Our reference: P-387860-Q0C5  
Contact: Kathryn Saunders, Principal Planner  
Telephone: (02) 4732 8567

**Modification Application - Aspect Industrial Estate  
SSD-10448 - MOD-3**

**Re: Supplementary Engineering Advice**

SSDA-MOD 3
ESTATE MASTERPLAN
DATE: 28.07.22 SCALE: 1:4000 @ A3 21/250 MP5-02 A

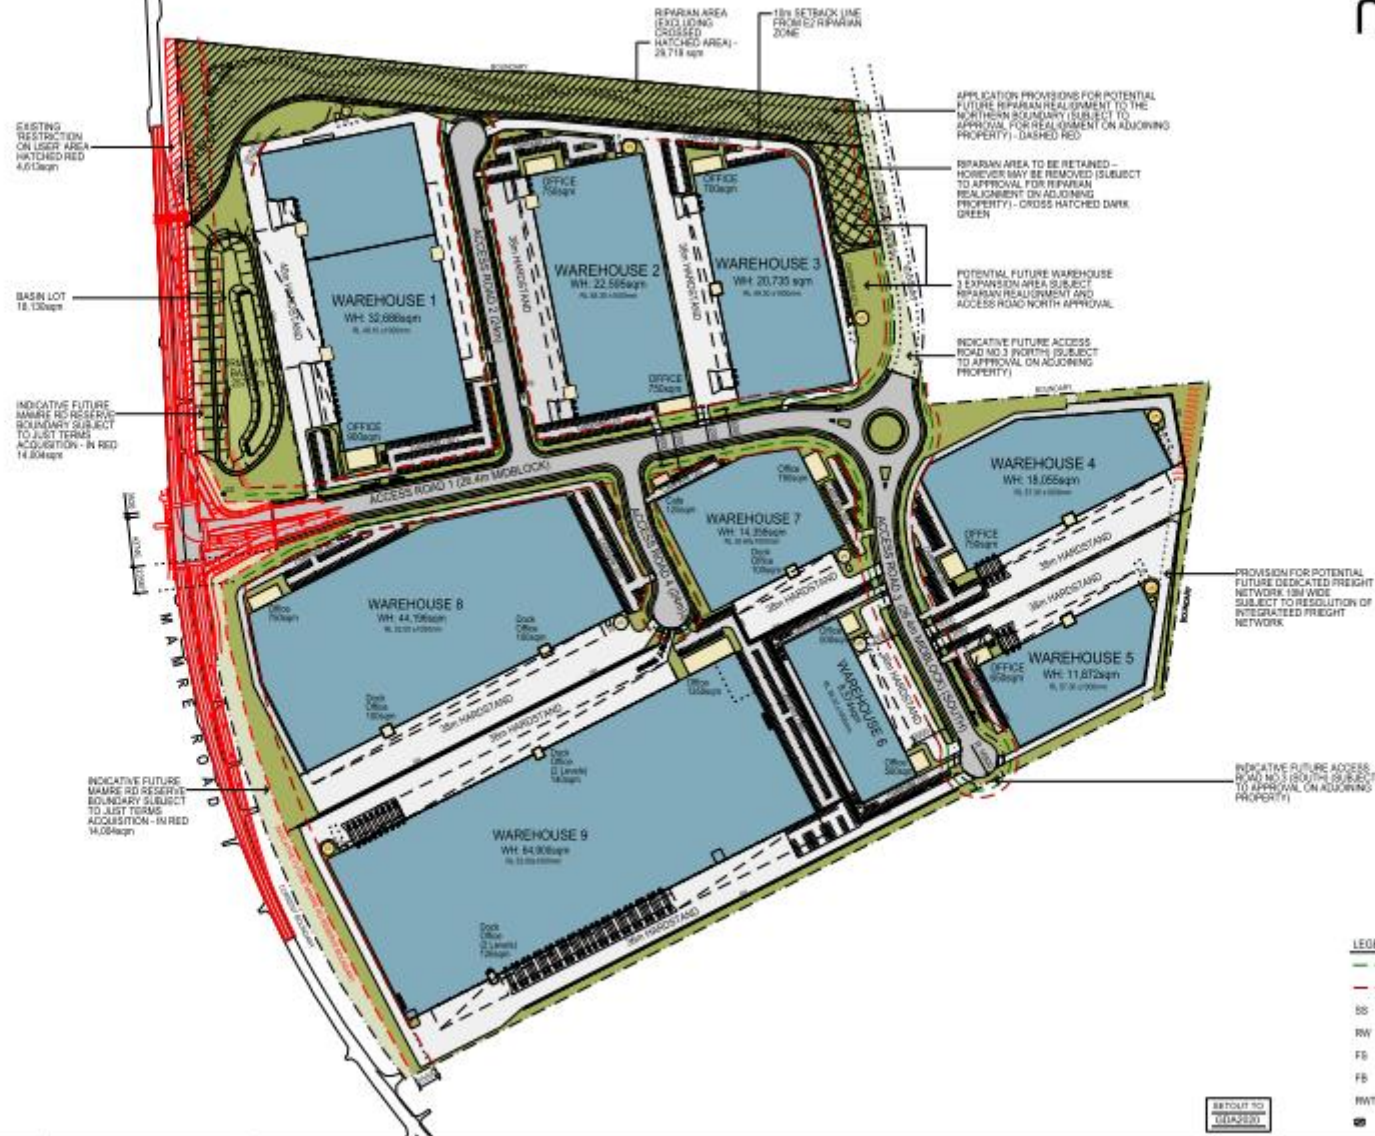
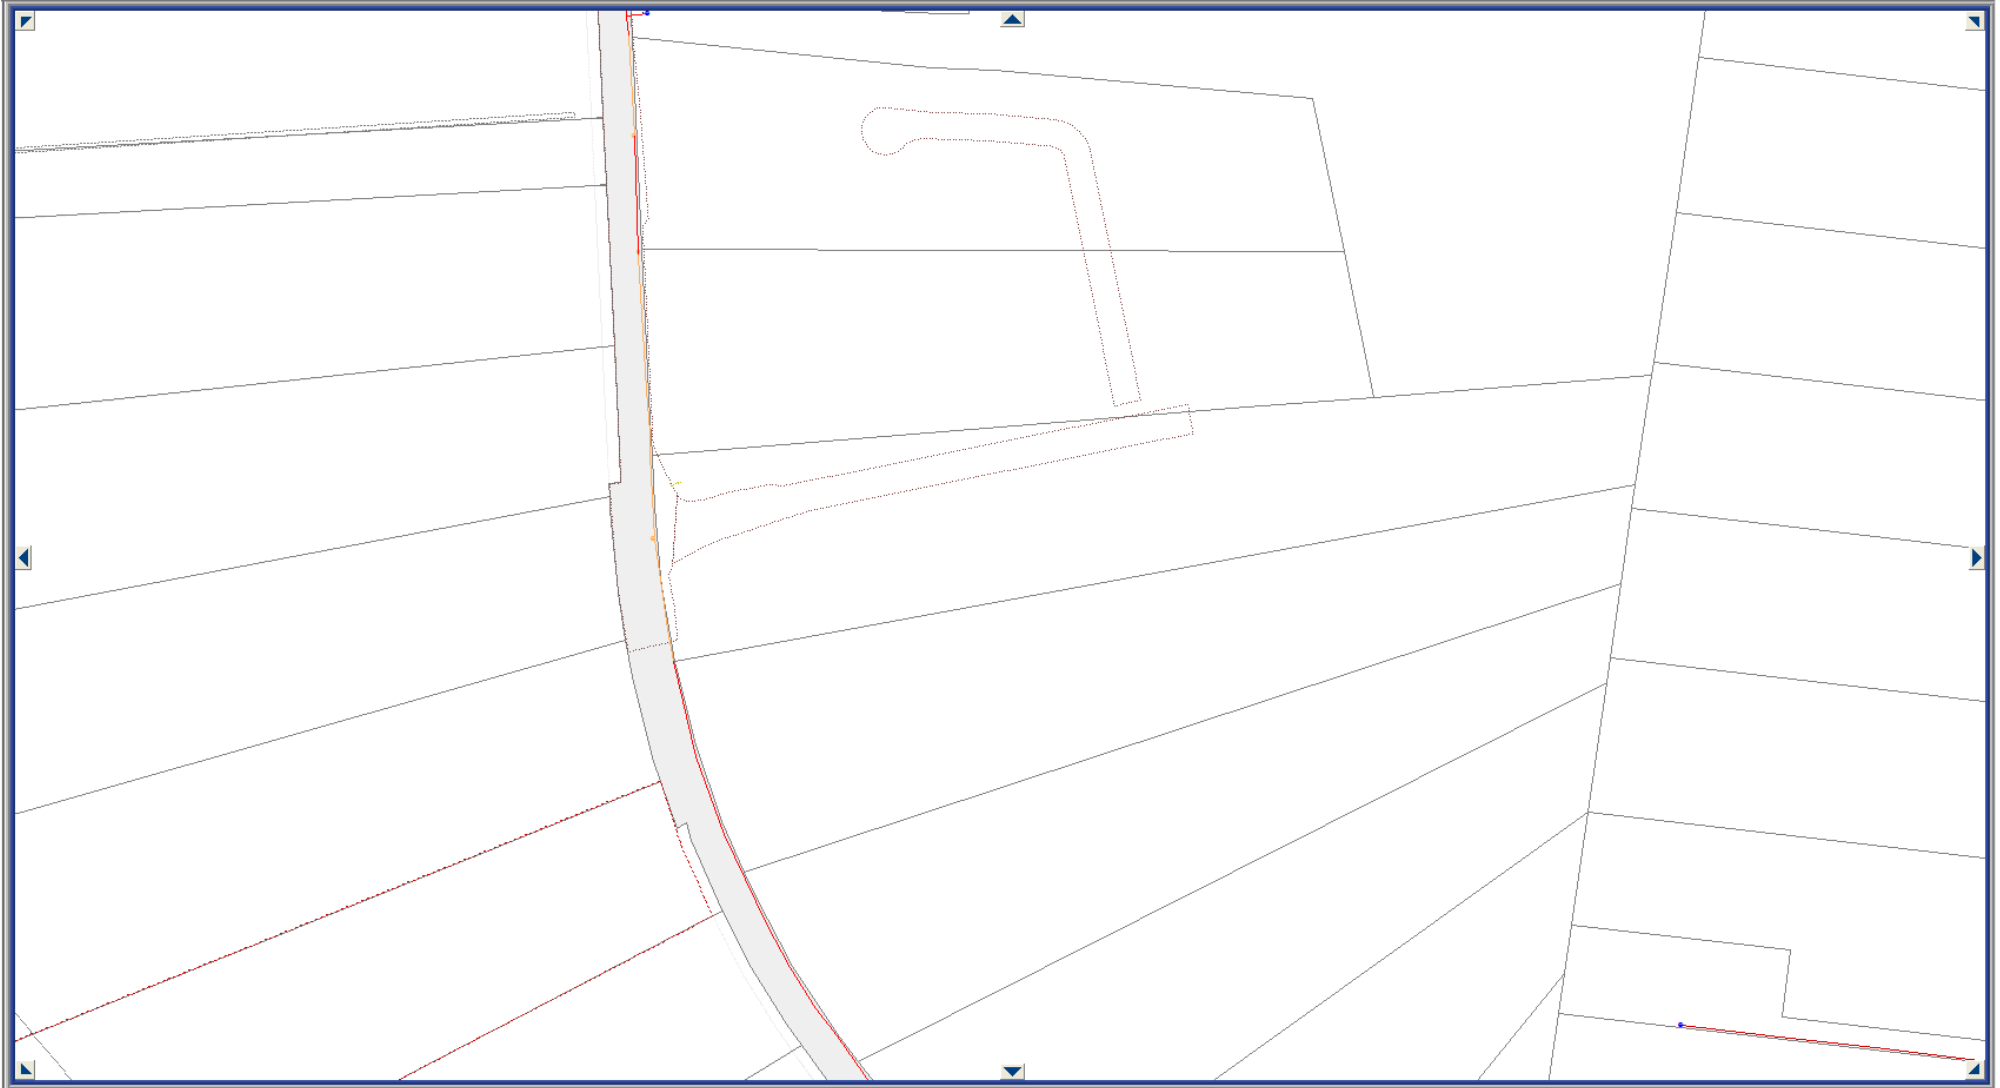
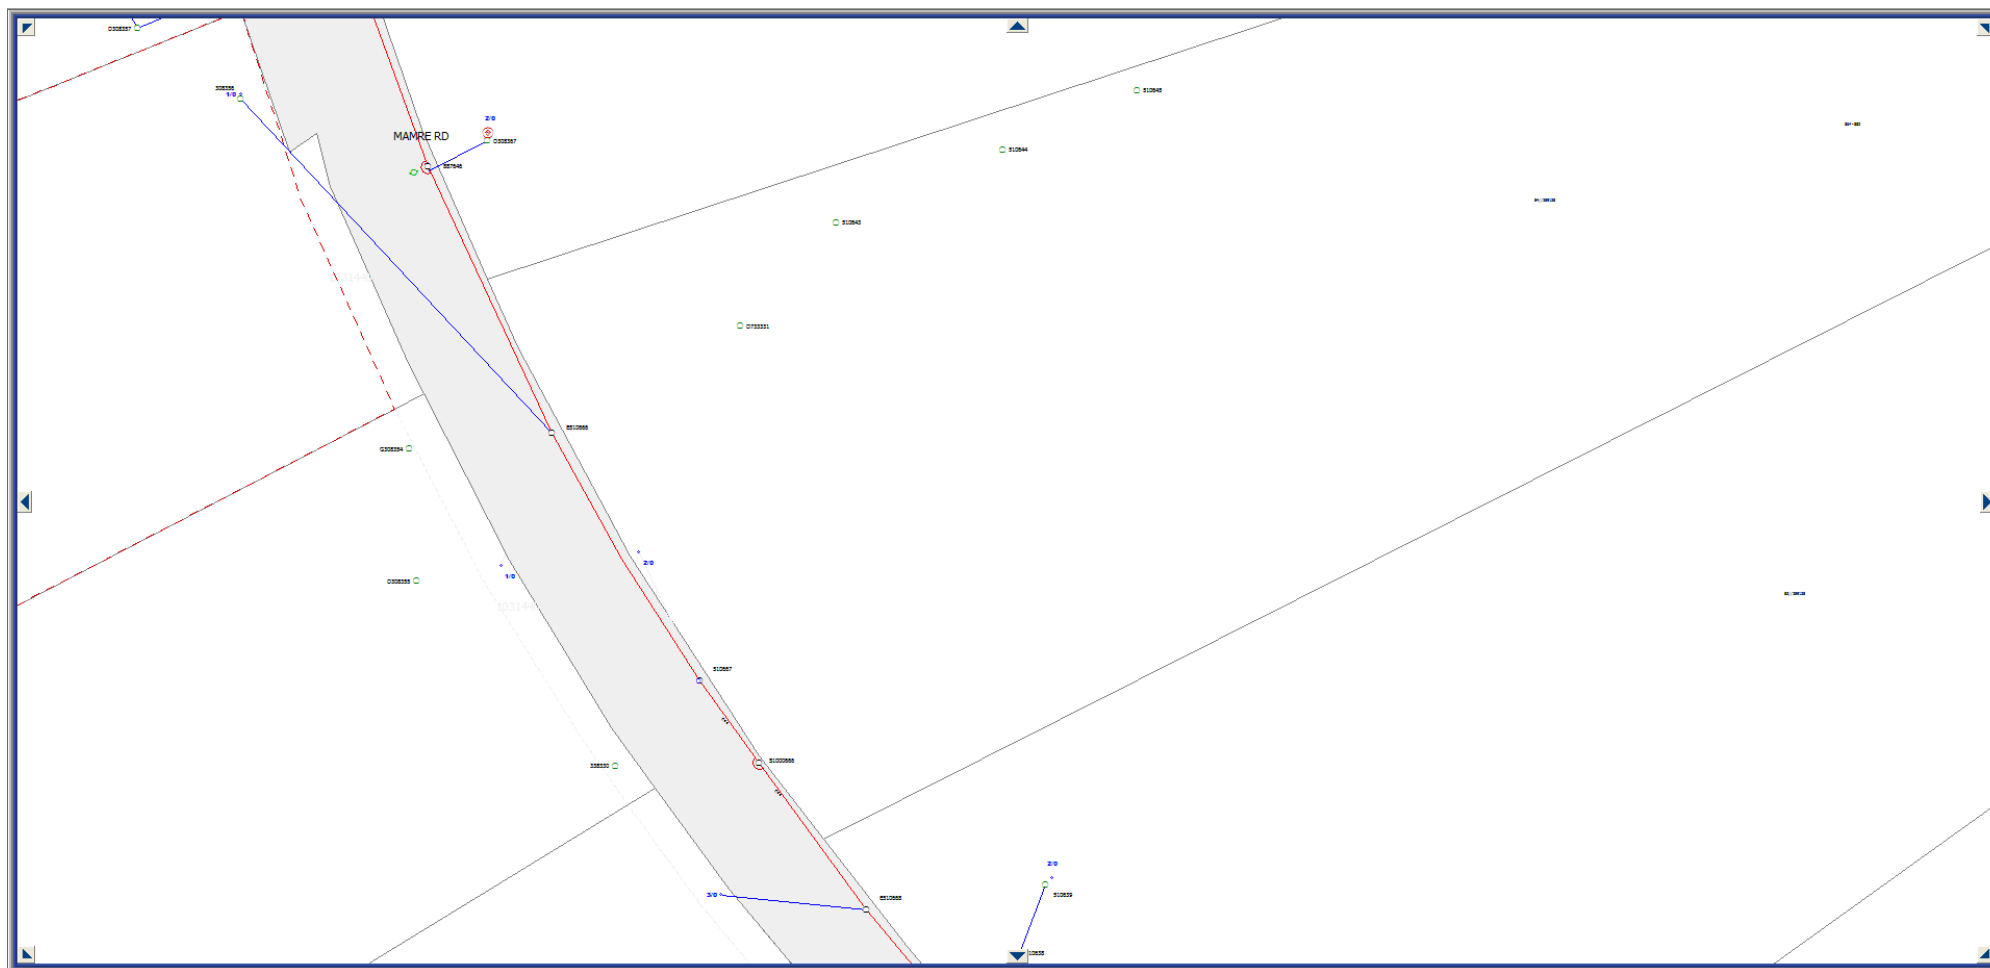
- **Internal Car Parking** - The internal car parking layout at the south-east corner of the site is not appropriate and should not be supported. All car parking areas for passenger cars should be physically separated from heavy vehicle access and manoeuvring areas by use of a kerb or other permanent feature. The use of bollards or line marking to separate heavy vehicle areas from car parking areas is not suitable from a safety perspective. Separate driveways from a public road should be provided for heavy vehicle access and passenger car access which is a consistent requirement of Council for all developments of this nature.

It is also noted that the car parking area in the south-east corner is utilised as part of the perimeter access for a fire truck, providing unimpeded access the fire truck. If the car park is physically separated from the heavy vehicle manoeuvring area by way of a kerb and a gap is left for fire truck access (as proposed) then the applicant is to demonstrate how this can occur.

- **Access driveways from cul-de-sac** - Consideration should be given to providing a mountable 'tear-drop' centre island within the cul-de-sac bulb to control traffic movements for multiple driveways.
- It is noted that the development proposes two electric vehicle charging stations noting the Mamre Road DCP is silent on required numbers of charging stations. This infrastructure is considered essential and is supported.
- **Stormwater Management**: All stormwater will be connected into the estate based drainage basins as approved under SSD-10448 and MOD3.

- All pad mount sub-stations are to be located within the site and not within the road reserve.
